3rd November 2011

The Town and Country Planning Act 1990 (as amended)

**Conservatory to rear elevation
63 Milton Avenue Rustington**

block plan 1/500

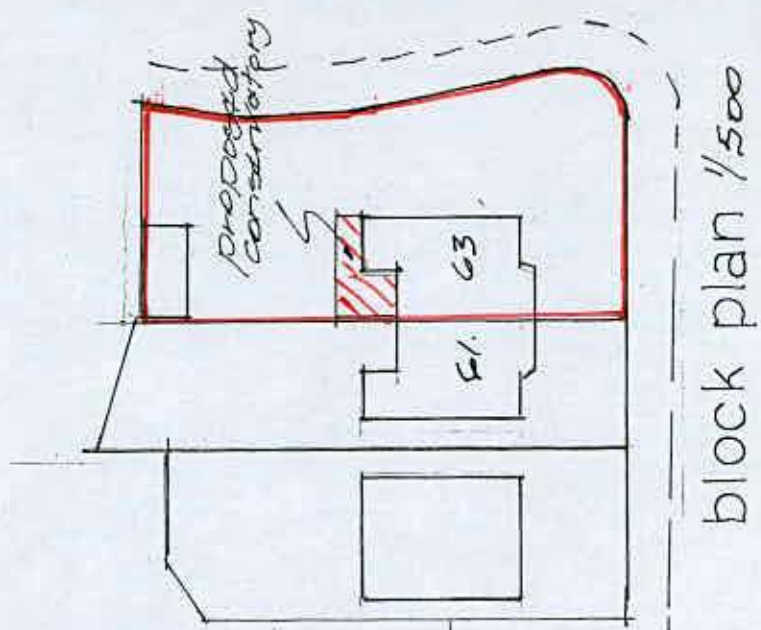
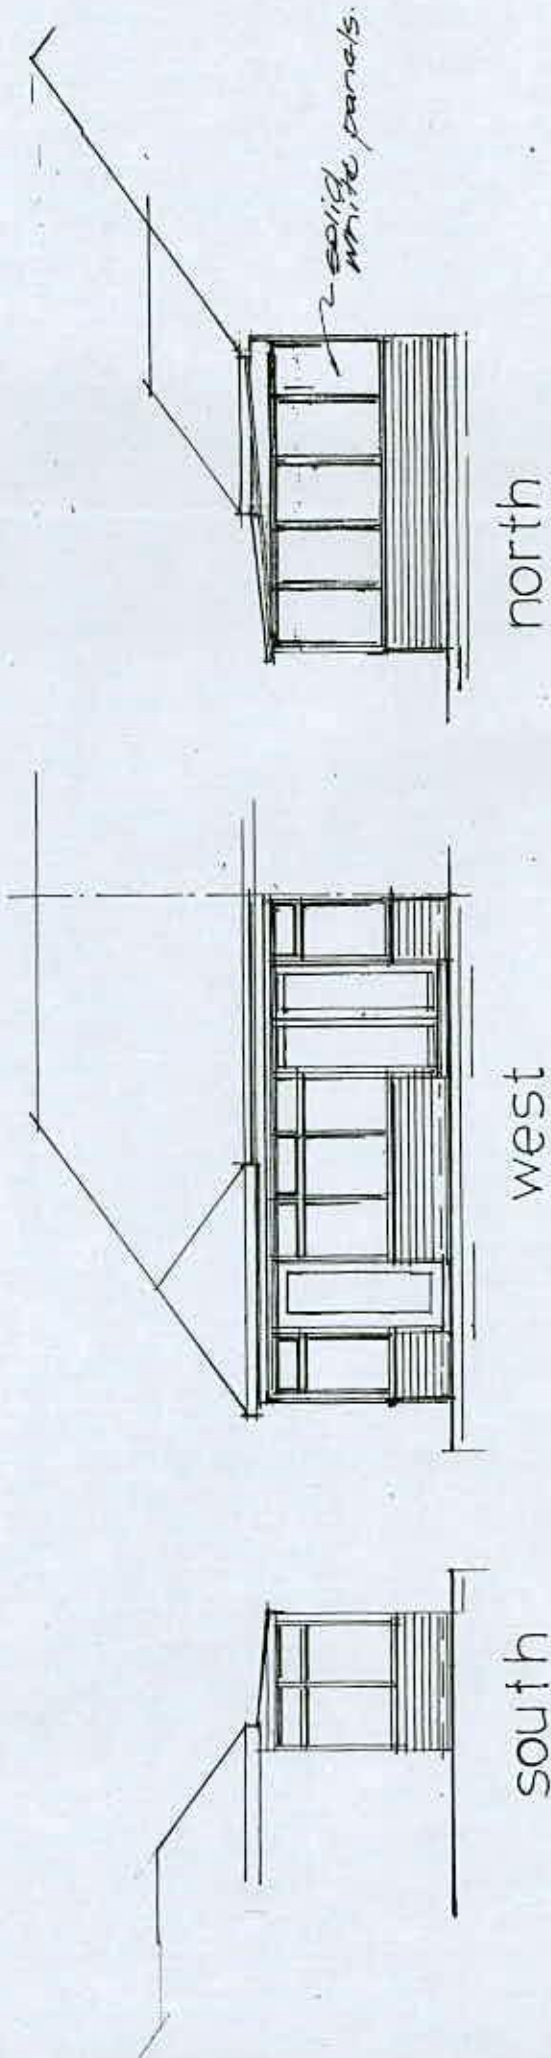
I require 1 electronic or 3 paper copies of a revised block/site plan to include 1 named road in accordance with the guidance notes available on our website detailed below (click on National List).
